WEST SUSSEX COUNTY COUNCIL CONSULTATION

TO:	Arun District Council FAO:Anita Gardner
FROM:	WSCC - Highways Authority
DATE:	5 May 2021
LOCATION:	Arundel Acre Arundel Road Angmering BN164EU
SUBJECT:	A/56/21/PL Change of Use of land from agricultural to storage site for up to 4 fairground rides, associated infrastructure (including MOT base) and erection of a storage shed.
DATE OF SITE VISIT:	n/a
RECOMMENDATION:	No Objection
S106 CONTRIBUTION TOTAL:	n/a / £ See below for breakdown.

ACCESS LOCATION SWEEP
PATH ANALYSIS

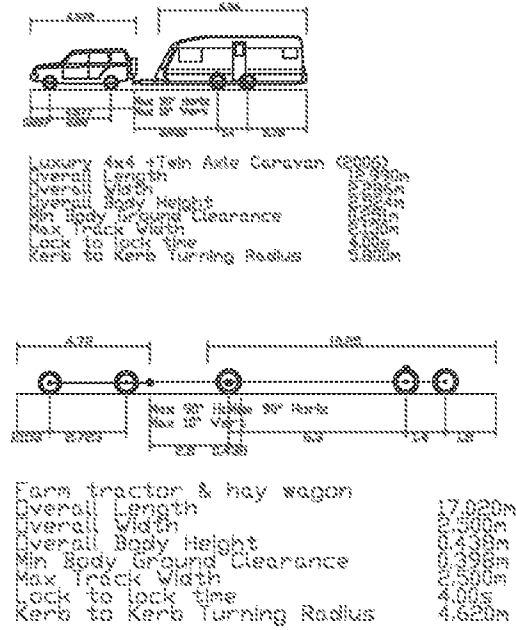
The access point in which the new use will operated from will not be changed and swept path diagrams show that this can be used without any difficulty. Whilst it is acknowledged the existing access does not provide the standard visibility splays recommend for the road, the applicant has undertaken some vegetation cut back to improve visibility here. It is also acknowledged the overall number of trips will see a significant net reduction in trips per year, from 1,512 for the agricultural use, to just 60 for the fairground storage proposed.
